## Attachment A – Response to Public Submissions (SSD 7275) 80-88 Regent St, Redfern

The following table includes a response to the submissions provided by the public. In total 18 public submissions (including 15 template submissions) were received in response to the public exhibition of the SSDA. The key issues identified have been categorised in the following table accompanied by the proponent's corresponding response in the right-hand column. The proponent's responses have been informed by input by the expert consultant team and should be read in conjunction with the publicly exhibited Environmental Impact Statement and accompanying technical reports, as well as the Response to Submissions Cover Letter to which this document is appended.

Roof Terrace level

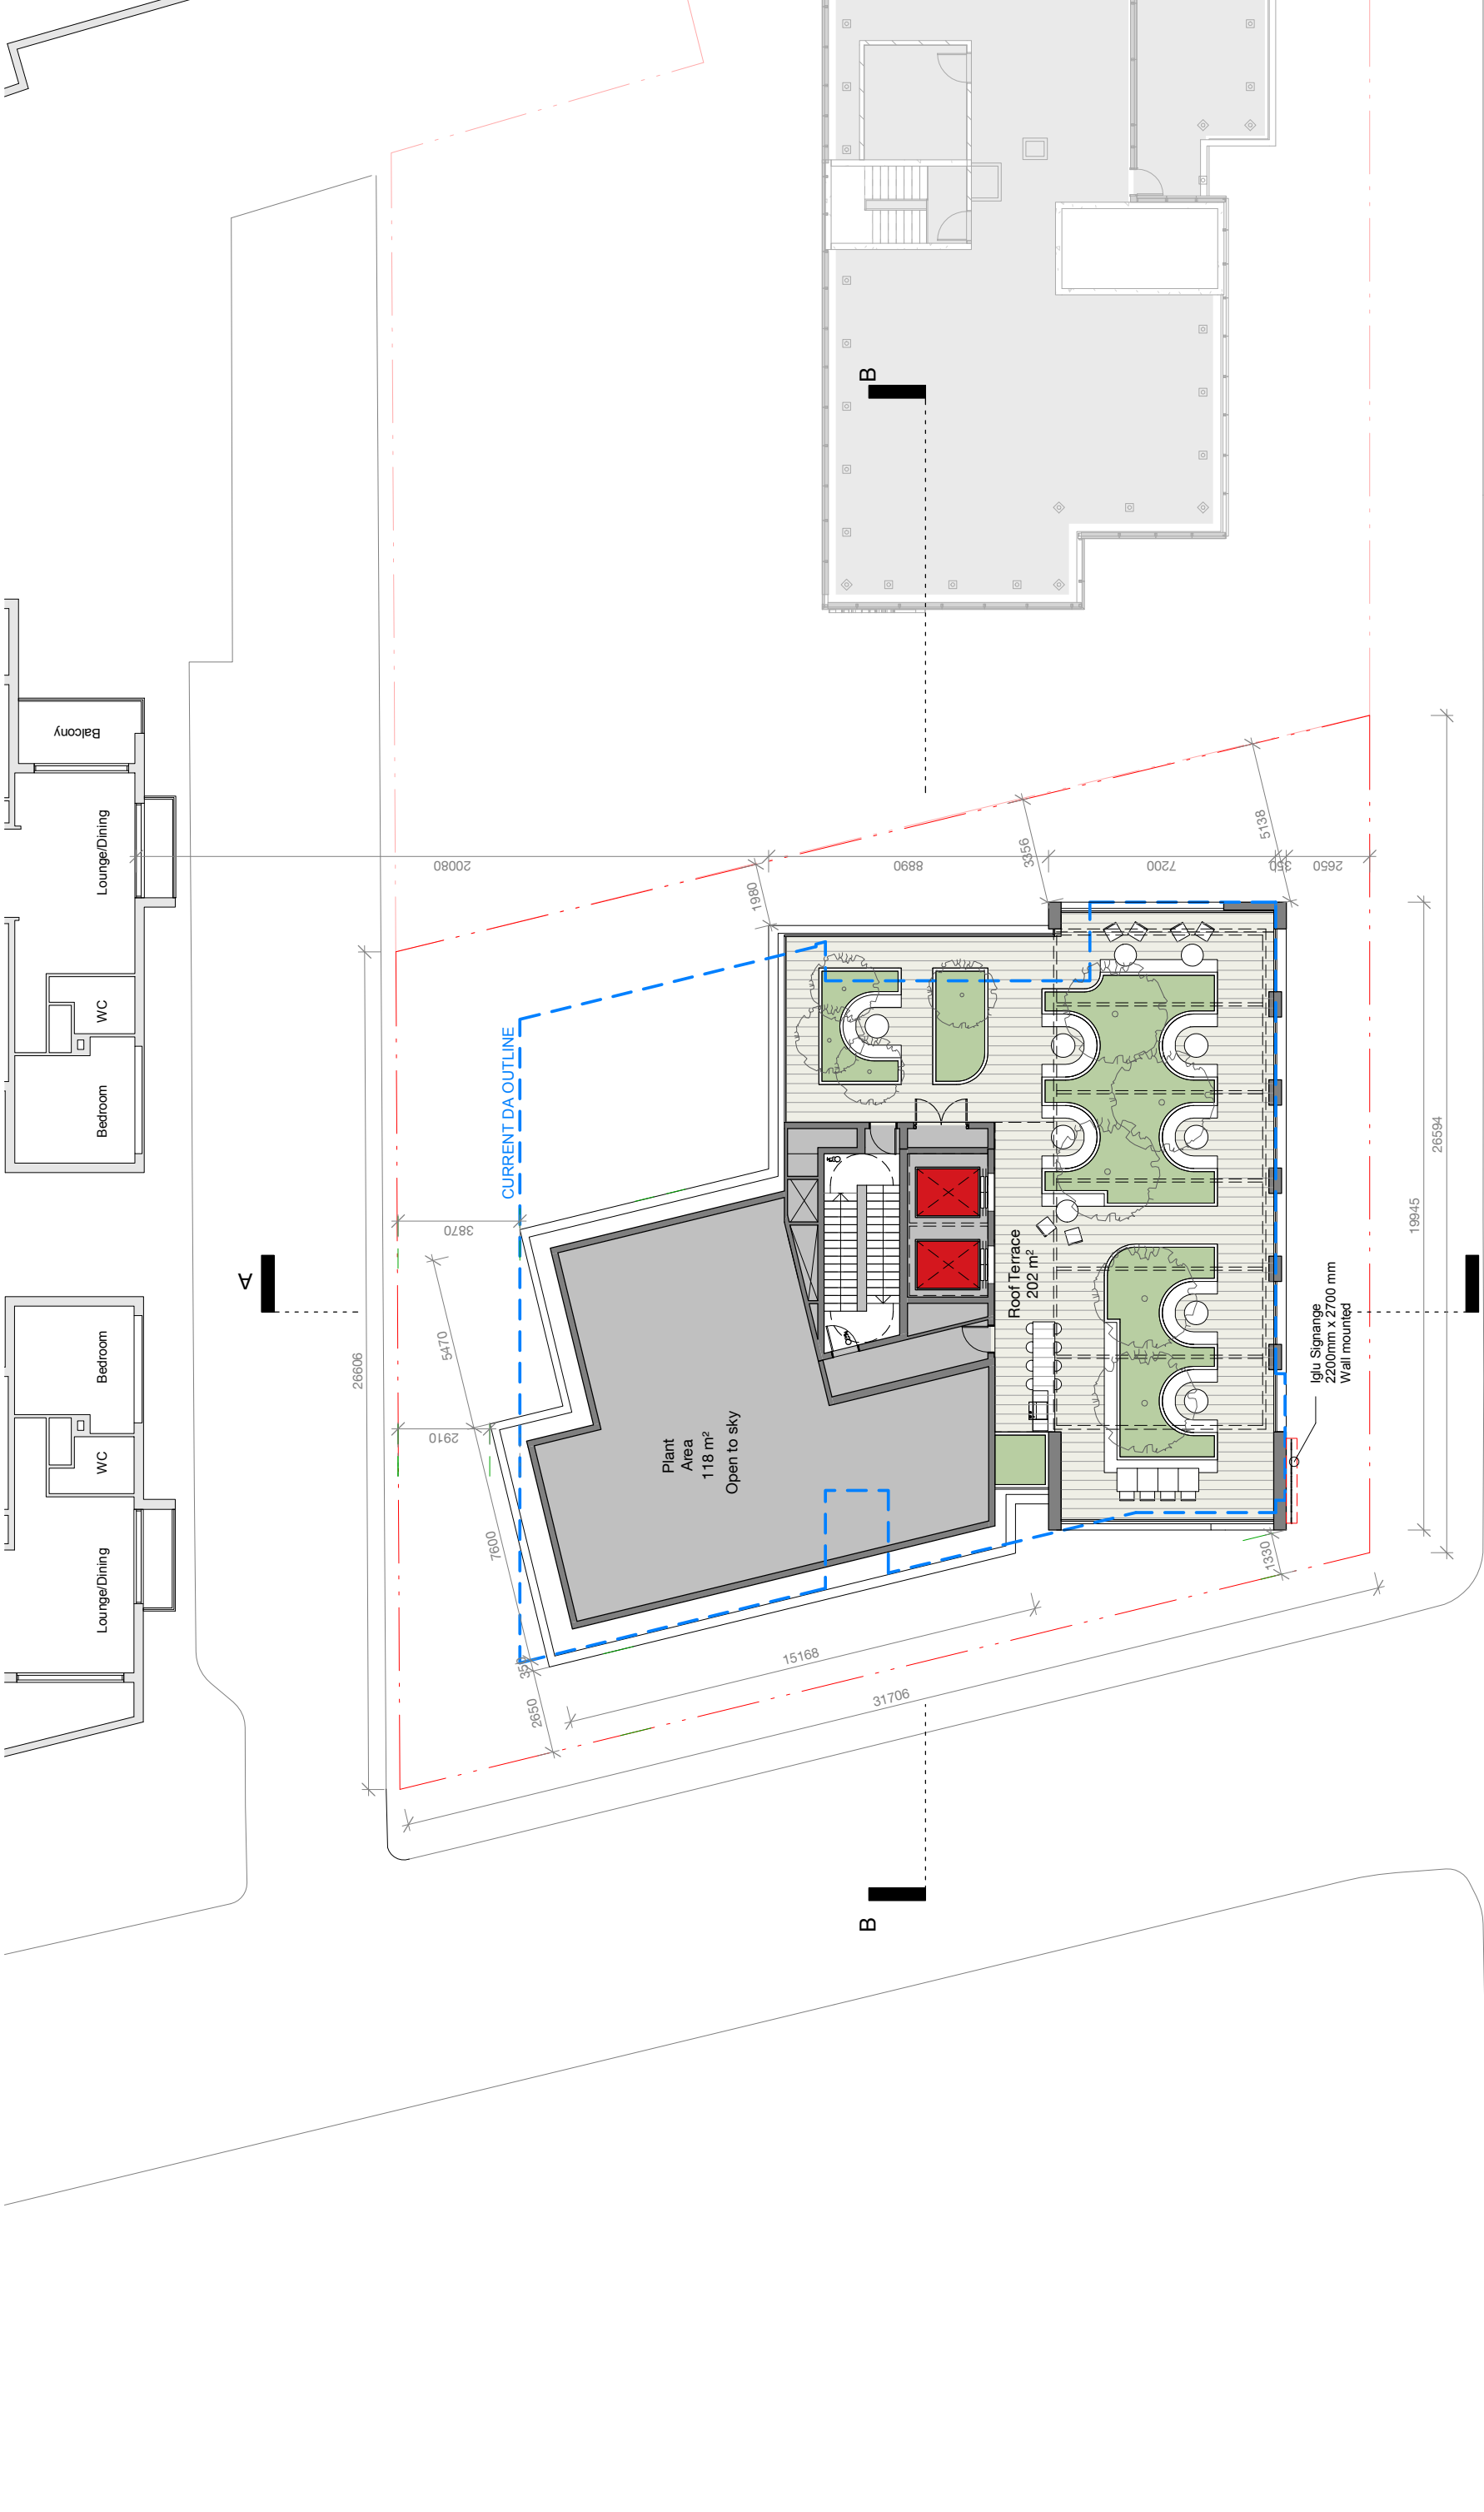
<b>5. Noise Impact</b>	
<ul style="list-style-type: none"> <li>Inadequate consideration has been made for the noise and privacy impact created by the lower terrace and the level 18 garden terrace. Being a communal area for students, the noise would be a serious impact on surrounding residences.</li> </ul>	<p>An Acoustic Impact Assessment was prepared by Acoustic Logic and was submitted with the EIS. The Acoustic Impact Assessment considered the impact of the rooftop terrace on surrounding residents. The predicted noise emissions were modelled based on a total of 100 people occupying this space at any given time and the sound power level of vocal noise from a patron is 75 dB(A) Leq, with one on two speaking at any one time. Acoustic treatments and management controls recommended include:</p> <ul style="list-style-type: none"> <li>The terrace must be restricted to a maximum of 100 patrons at any given time.</li> <li>The terrace cannot be used during the night-time period (10pm-7am).</li> </ul>

Item Raised	Proponent's Response
	<ul style="list-style-type: none"> <li>No amplified music is permitted in this space.</li> <li>Construct a solid screen (FC, timber, glass, Perspex etc.) on top of the parapet wall as illustrated below. Total height (including) parapet must be 2m.</li> </ul> <p>The Applicant supports these recommendations being imposed as a condition on any development consent to ensure the use of the rooftop terrace has acceptable acoustic amenity for surrounding residents.</p> <p>In terms of privacy, the rooftop terrace is oriented to the east, and is setback over 20m from the nearest residential apartment to the west. In addition to the large separation, the rooftop terrace includes landscaping that would obscure direct sight lines to the west. As such, the privacy impacts are considered minimal.</p>
<b>6. Built Form and Heritage Value</b>	
<ul style="list-style-type: none"> <li>Due to the proposed exceedance of the maximum building height control established under the Redfern Waterloo Authority 'Urban Design Principles – Redfern Centre,' which would limit development to 12 storeys on the site, and minimal setbacks to the common property boundary, the proposed development has the potential to have significant privacy and visual impacts on the surrounding developments. Under Section 4.2 of the Redfern Waterloo Authority 'Urban Design Principles – Redfern Centre,' tower-form buildings above podium level are required to provide a minimum separation distance of 13 metres below 8 storeys and 18 metres above 8 storeys, which this development does not.</li> </ul>	<p>The <i>State Environmental Planning Policy (State Significant Precincts) 2005</i> establishes the following maximum building height controls for the site:</p> <ul style="list-style-type: none"> <li>two storeys to a depth of 8 metres from the Regent Street property boundary;</li> <li>three storeys to a depth of 4 metres from the Marian Street property boundary;</li> <li>18 storeys for the remainder of the site.</li> </ul> <p>As identified in the SEPP 1 Objection submitted with the EIS, the height variation only relates to the 2-storey building height development standard. The proposed development is consistent with the maximum building height of 18 storeys and is smaller in height than the approved building under SSD 7080.</p>
